Helios EN010140

One last plea for Common Sense, Hope and what the people of Camblesforth deserve.

The Battery Energy Storage System (BESS) plus the 132Kv Sub Station

Environmental Statement Figure 11.4: Noise Contour Map Daytime

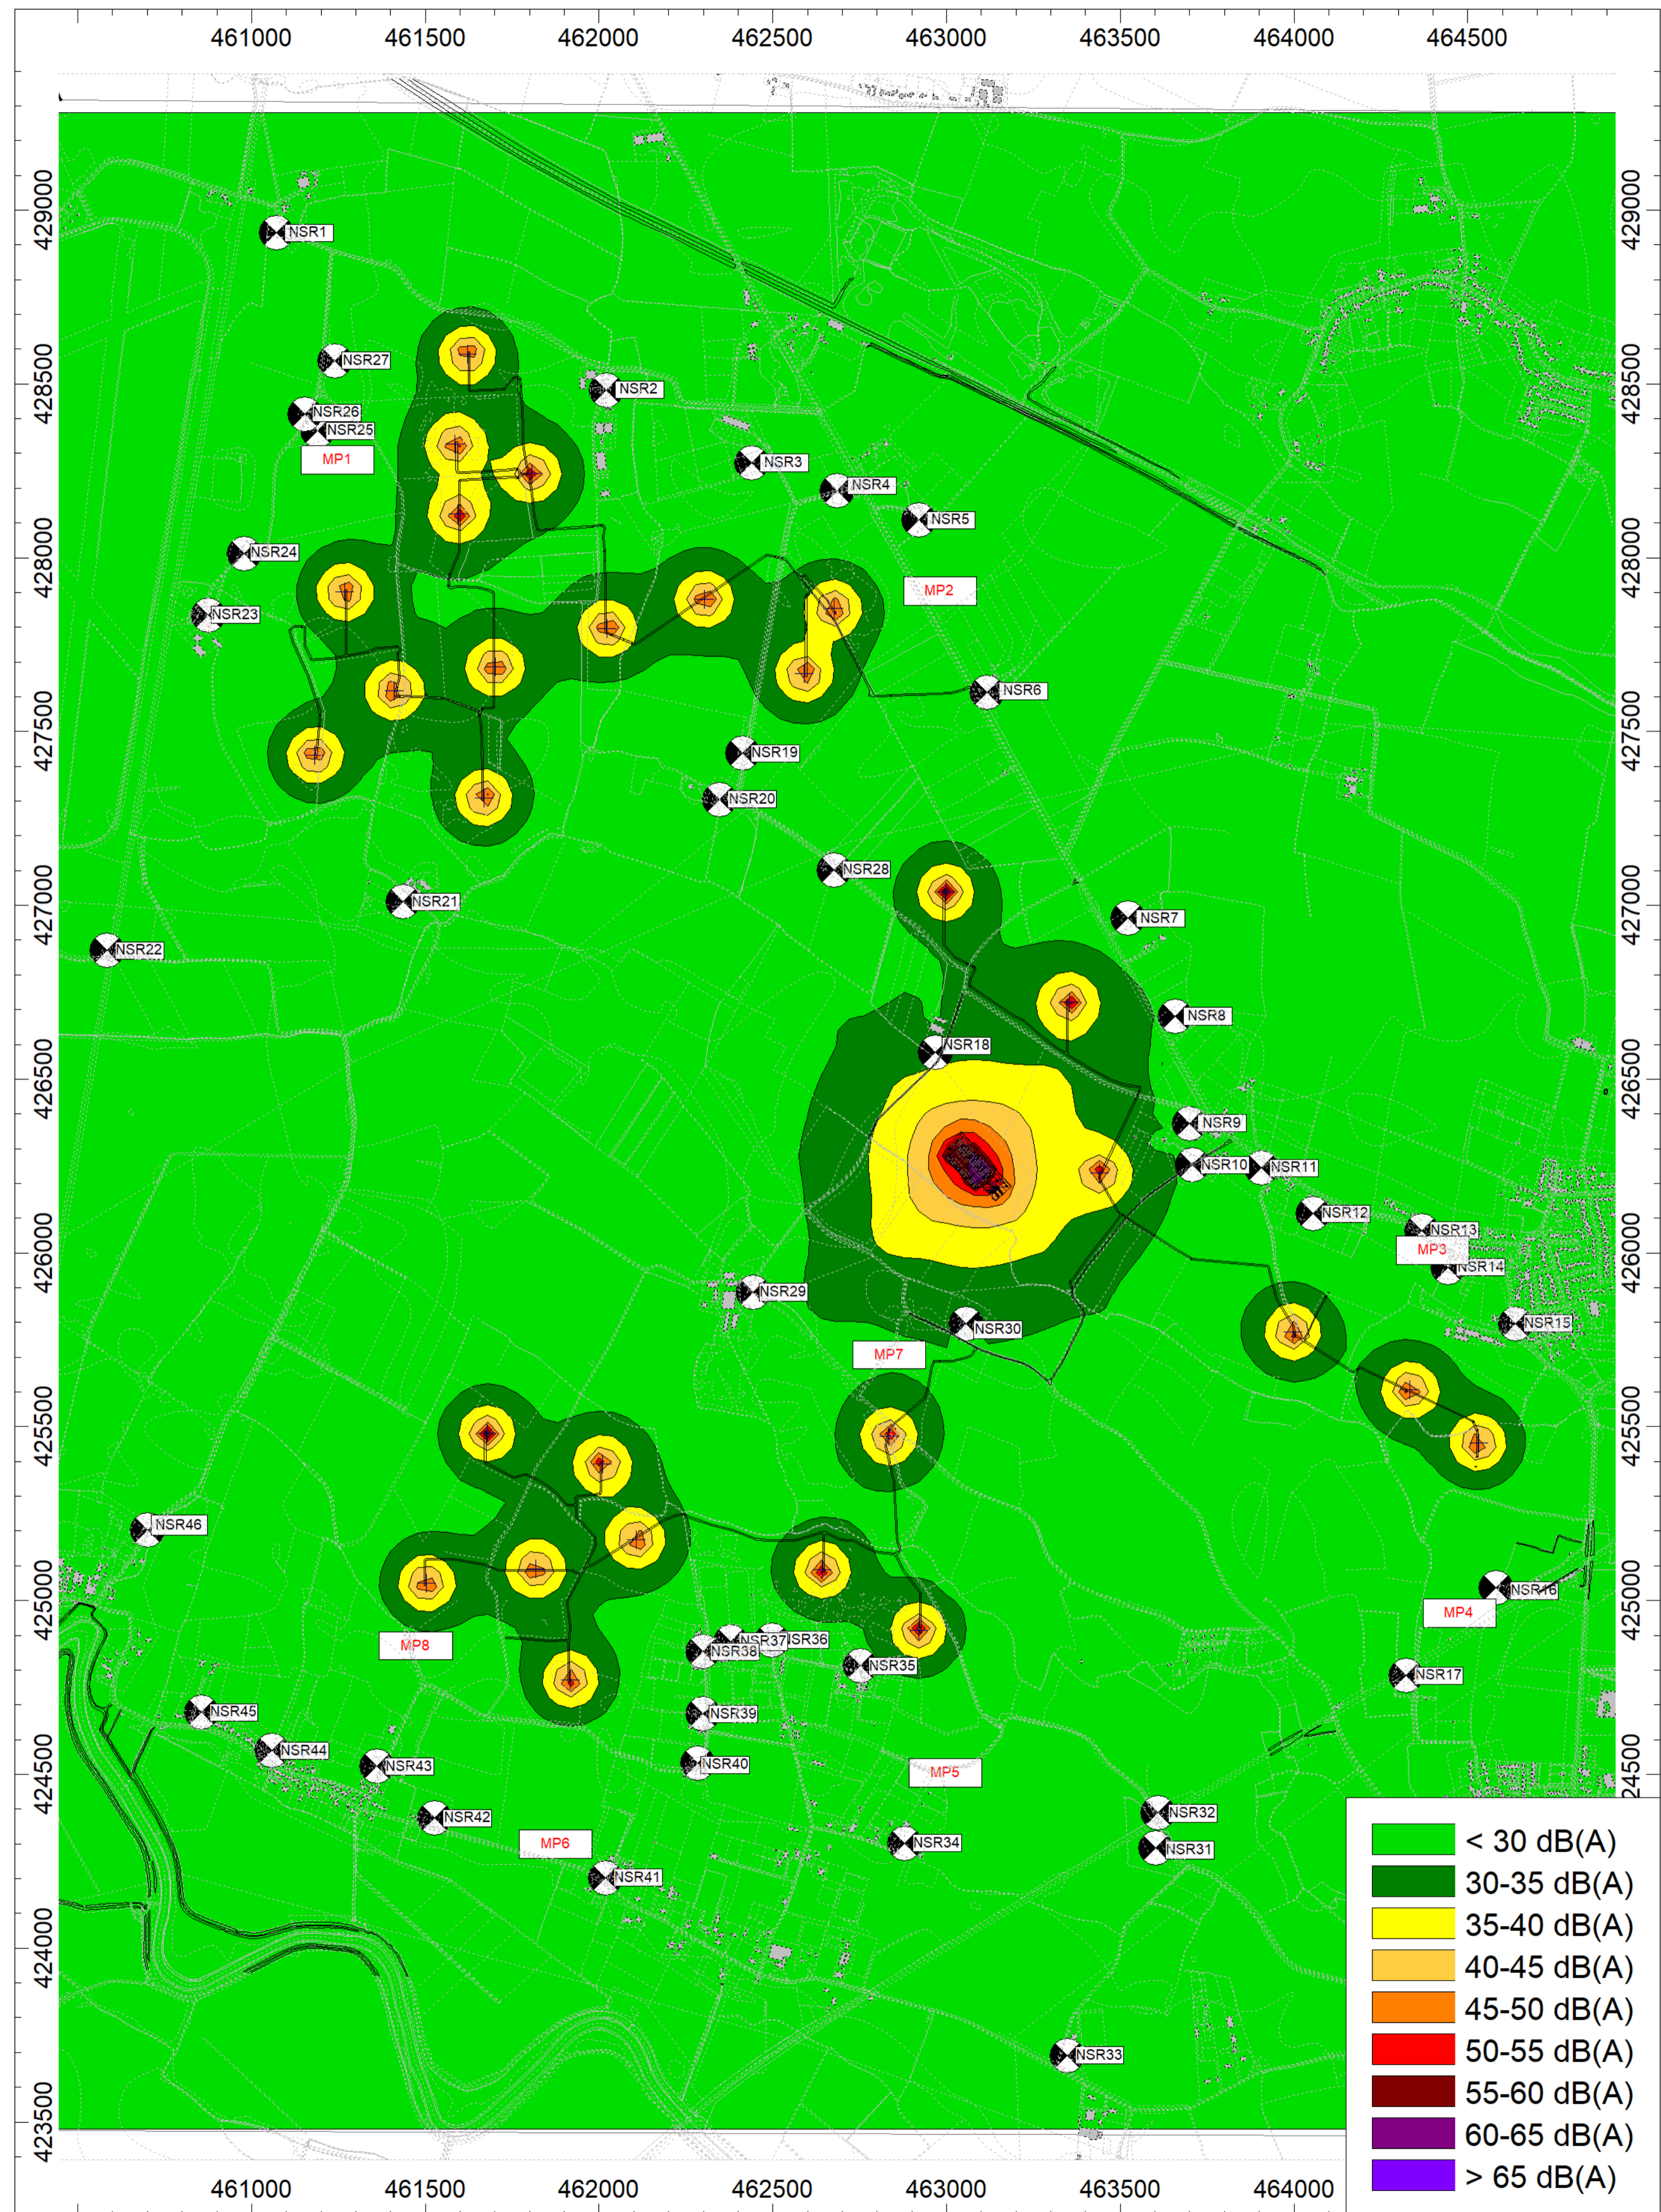
With Reference to Environmental statement Figure 11.4

(The map I have supplied number 7), has a symbol Z? which I have added. Whatever it/they are. (counted 28) They have the capability of emitting 45-50 dB of noise. The Z? in question is ALMOST [REDACTED]

Due to the poorly detailed map, I could not get a Fix position to measure approx., how close it is.

On the poorly detailed Map Fig 11.4 – Noise Contour Map Daytime, (my ID Map 7). I would like some independent assurance, that *as if by some miracle*, we are in the < 30 dB zone.

## **Environmental Statement Figure 3.7: BESS Battery Container Elevations**

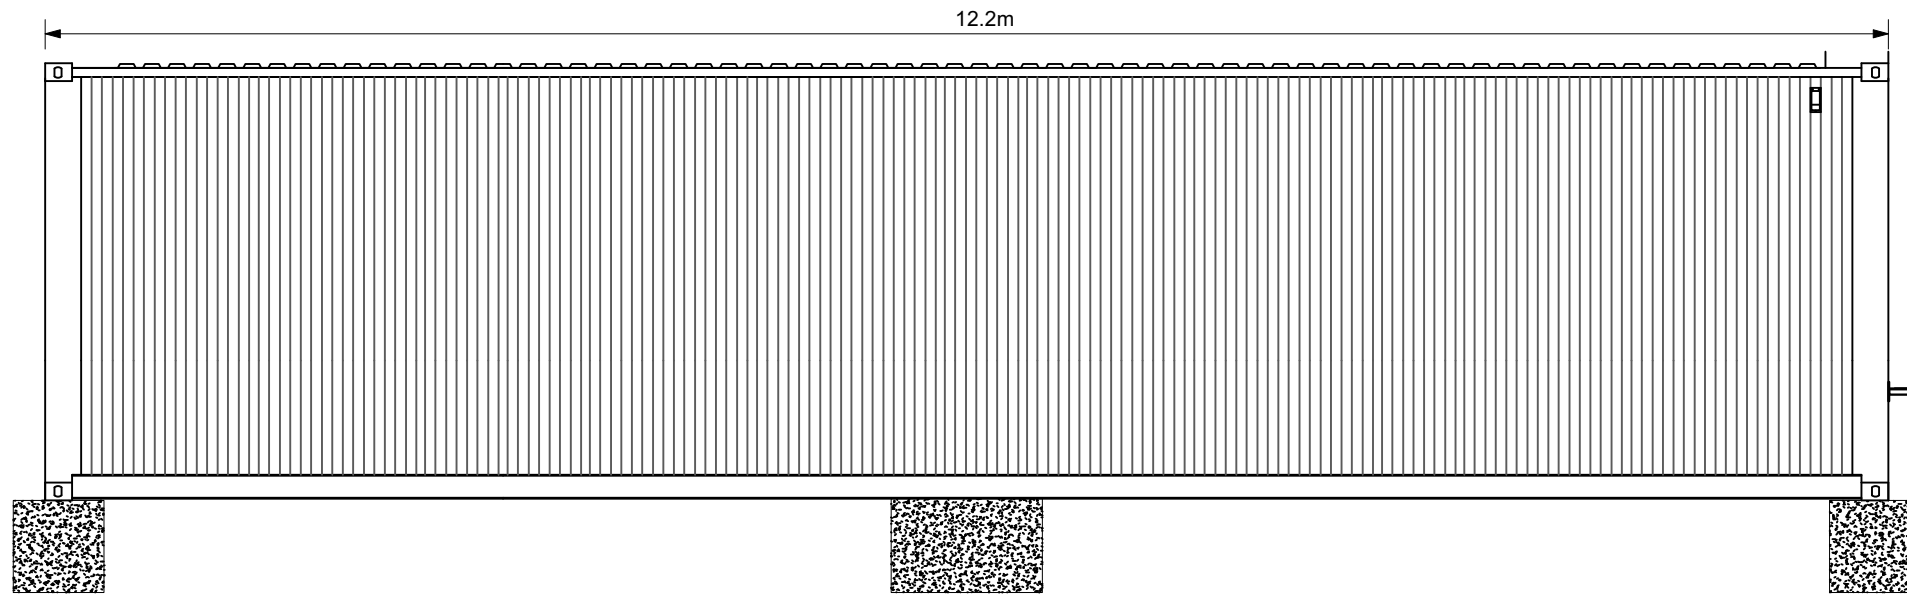
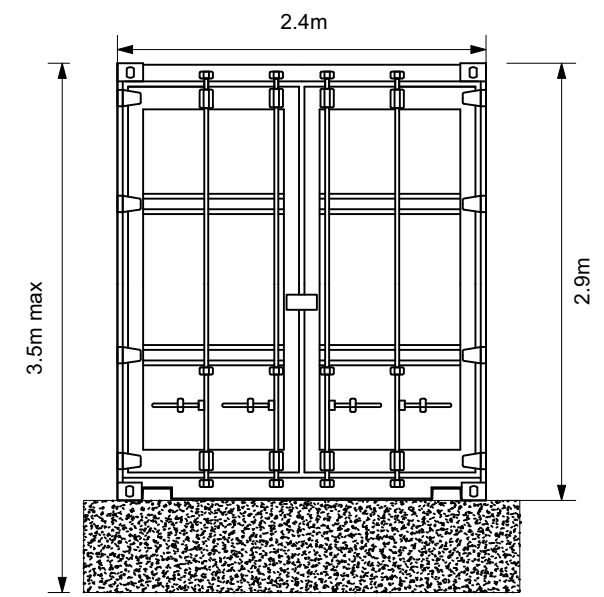
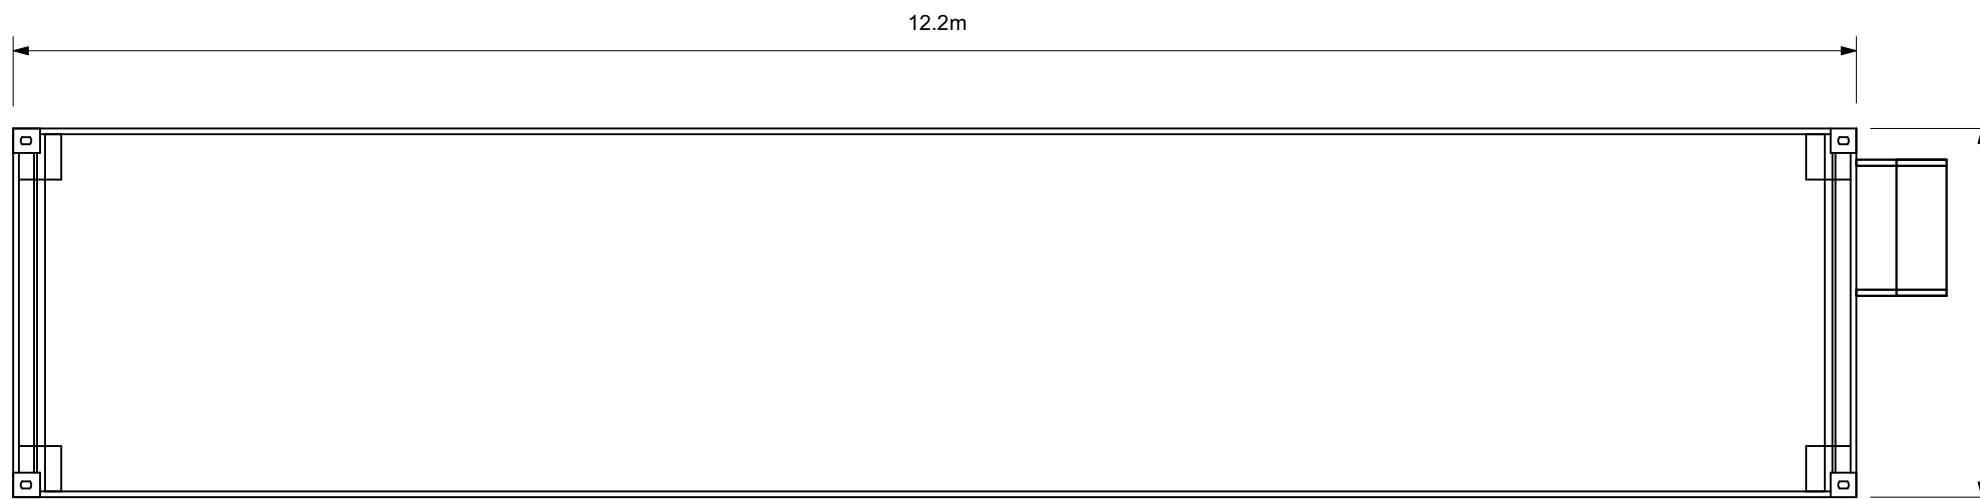
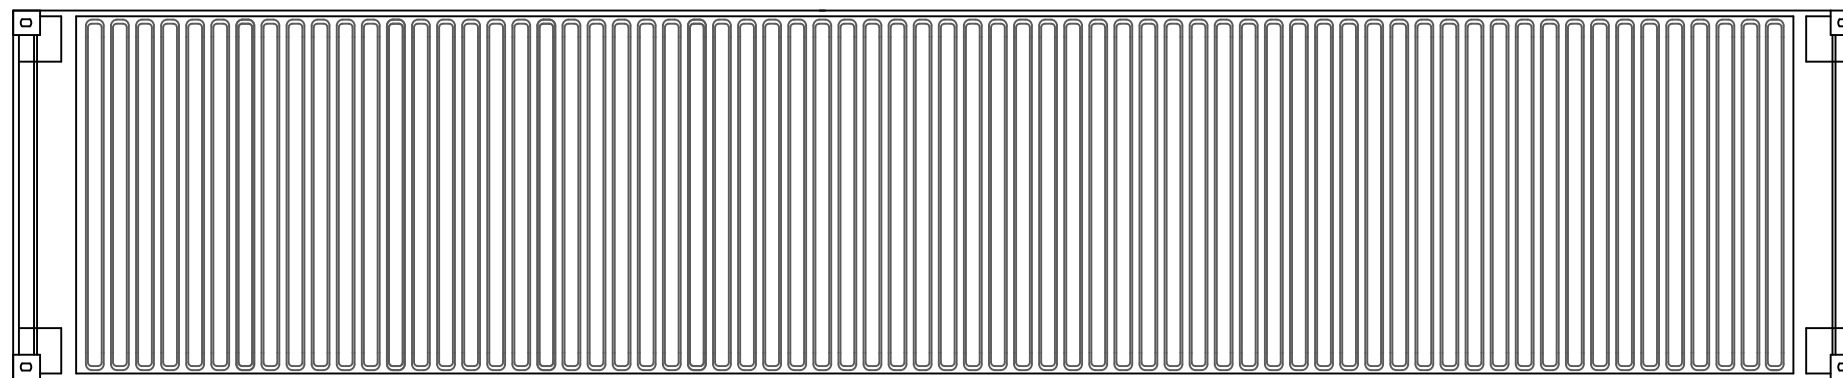
3.4.22 Battery containers (separate from Field Stations and Inverter Stations)

12.2m in length x 2.4m Width x 3.5 in height.

4. It does not say how many?
